CITY OF ALBUQUERQUE
Albuquerque, New Mexico
Planning Department

INTER-OFFICE MEMORANDUM

SUBJECT: **AC-07-2 – 06DRB-01411; 01412; 01413; 01414; 01415; Project # 1004989** Hess Yntema, agent for Carl & Lillian Fesler, appeals the Development Review Board's approval of a Preliminary Plat, Vacation of Public Easements, Subdivision Design (DPM) Variance; Sidewalk Waiver; and Temporary deferral of Sidewalk for all or a portion of Tract(s) A, Unit 2, Wilderness @ High Desert (to be known as ~~Wilderness Canon @ High Desert~~)-zoned SU-2, HD/R-R, located on High Desert Place NE, between Trailhead Road NE and Embudito View Ct NE, containing approximately 4 acre(s). (F-23) Sheran Matson, DRB Chair

PRELIMINARY PLAT WILDERNESS CAÑON AT HIGH DESERT (TRACT A OF UNIT 2 WILDERNESS) ALBUQUERQUE, NEW MEXICO OCTOBER, 2006

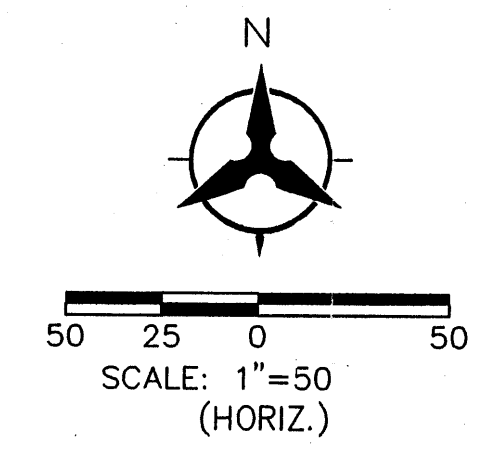
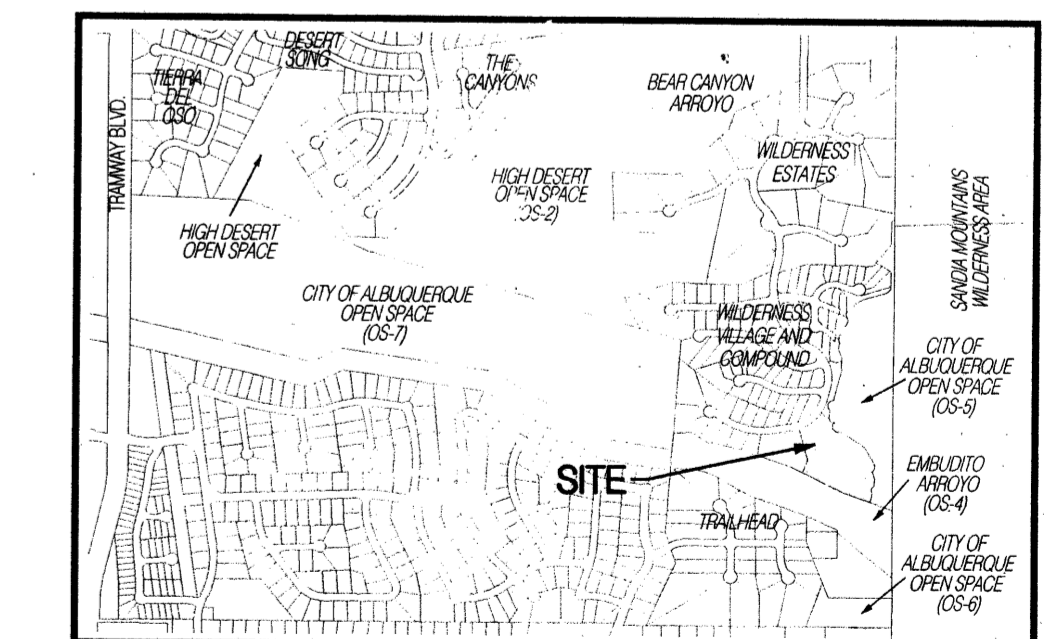
The Sector Plan does limit the density in the SU2-HD RR zone to 13 dwellings units per acre. The preliminary plat for Wilderness Canon at High Desert is approved at 6.32 dwelling units per acre, one half the allowed density. (SEE EXHIBIT C.)

The RG zoning category refers to the City RT Residential Zone category to determine lot size. The minimum lot size for RT zoned property is 3,600 square feet and 36 foot minimum lot width. (SEE EXHIBIT D.) This plat meets the lot size requirements

In compliance with Section 4.A.7 of the Sector Plan, the Development Review Board (DRB) received a letter dated November 6, 2006, from Raymond S. Berg, President of the Board of the HDROA. In that letter, Mr. Berg states the HDROA reviewed the proposed Wilderness Canon at High Desert plat and confirms that the plat is consistent with the underlying zoning requirements of the High Desert Sector Plan. In addition, the letter states that the HDROA agrees that the number of dwelling units in the plat does not exceed the maximum number allowed. (SEE EXHIBIT F.)
